ACCESS REPORT

STATE SIGNIFICANT DEVELOPMENT APPLICATION SSDA 7689

WALSH BAY ARTS PRECINCT

4th November 2016

1 SHORE SHEDS SOUTH ELEVATION (HICKSON ROAD) - PROPOSED

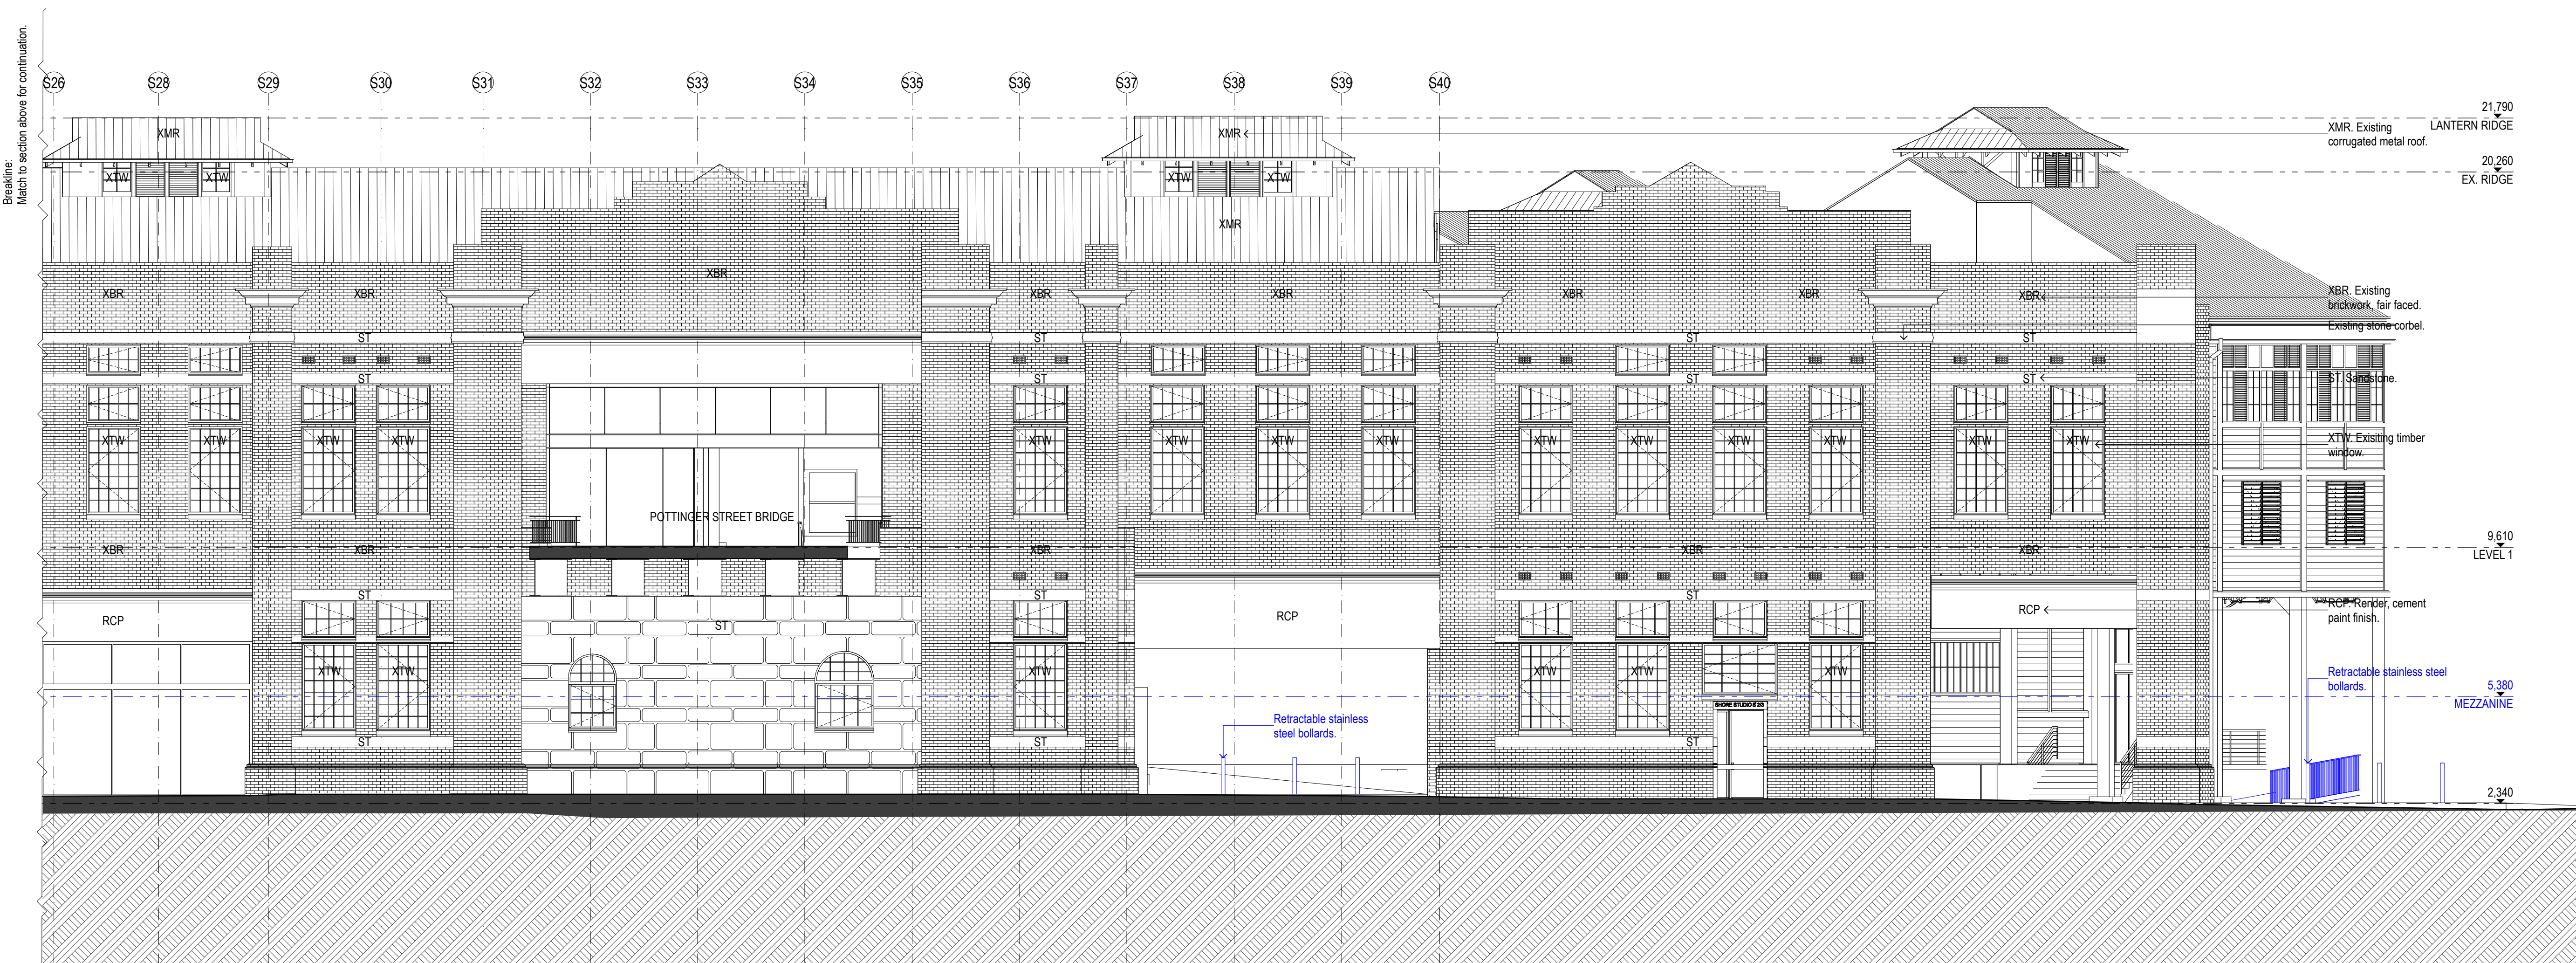
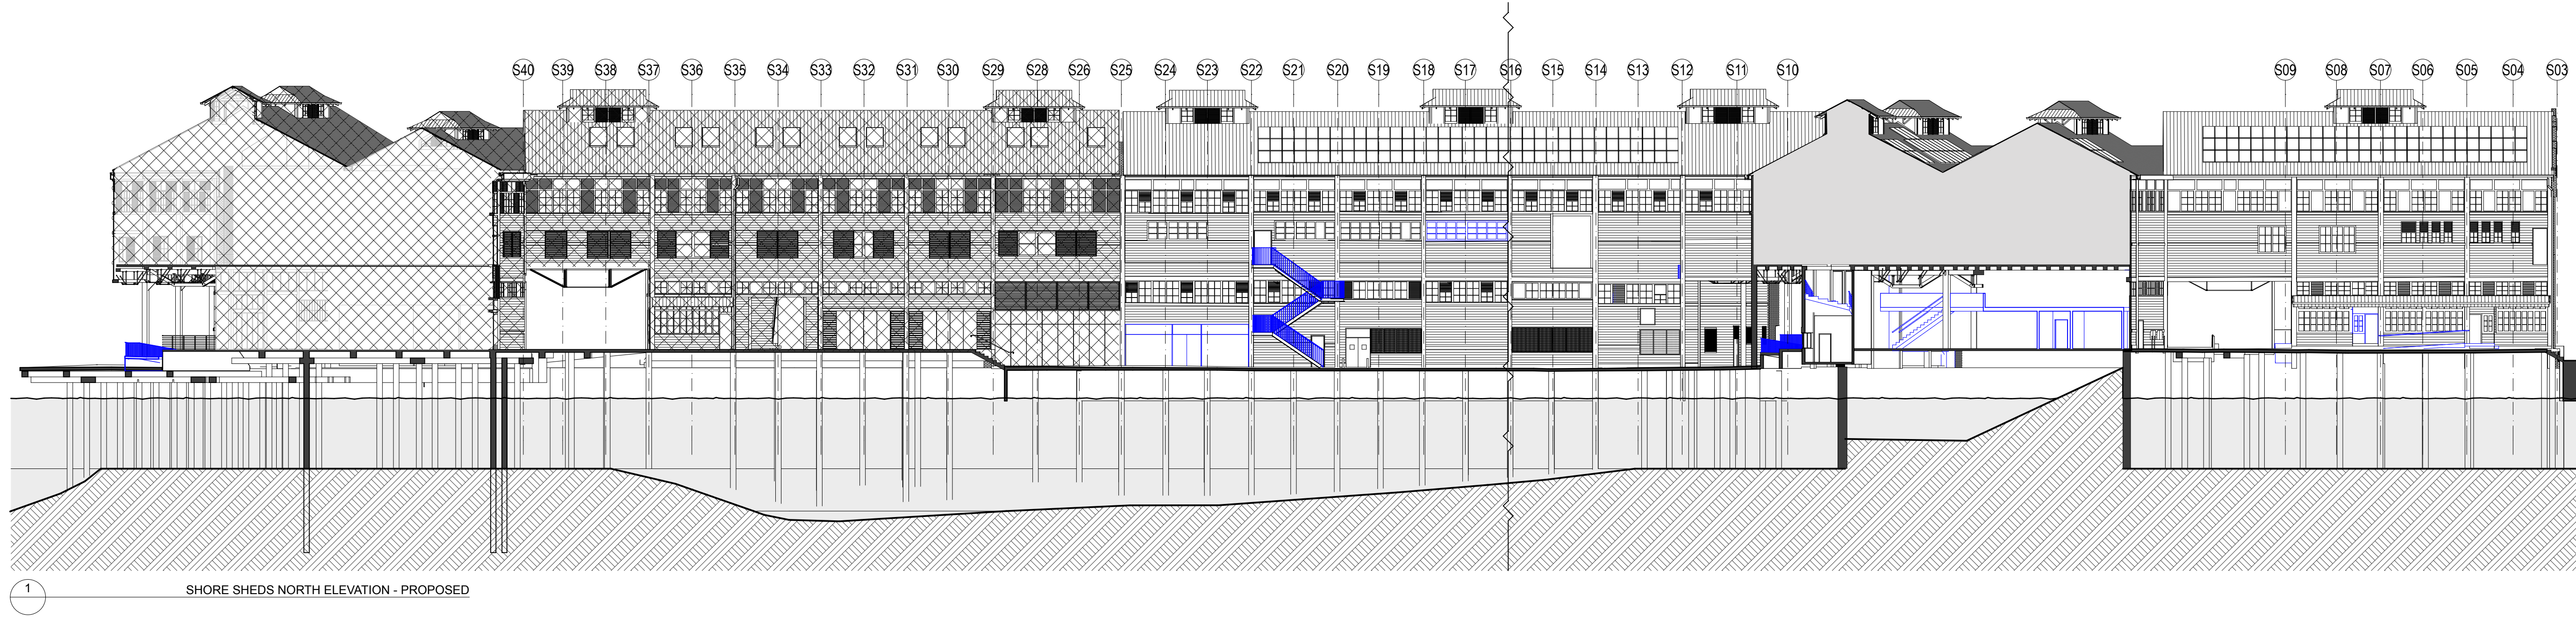
BCA / DDA Access Code Review	Compliance
egress stair which requires a suitable barrier to mitigate hazards consistent with ASI428.4.1 and comply with Part D3.8 of the BCA.	
30. Shore Shed 5 contains a commercial no. 2 tenancy that proposes an external ramp to eliminate the two steps to comply with ASI428.1 and satisfy D3.2 of the BCA.	YES
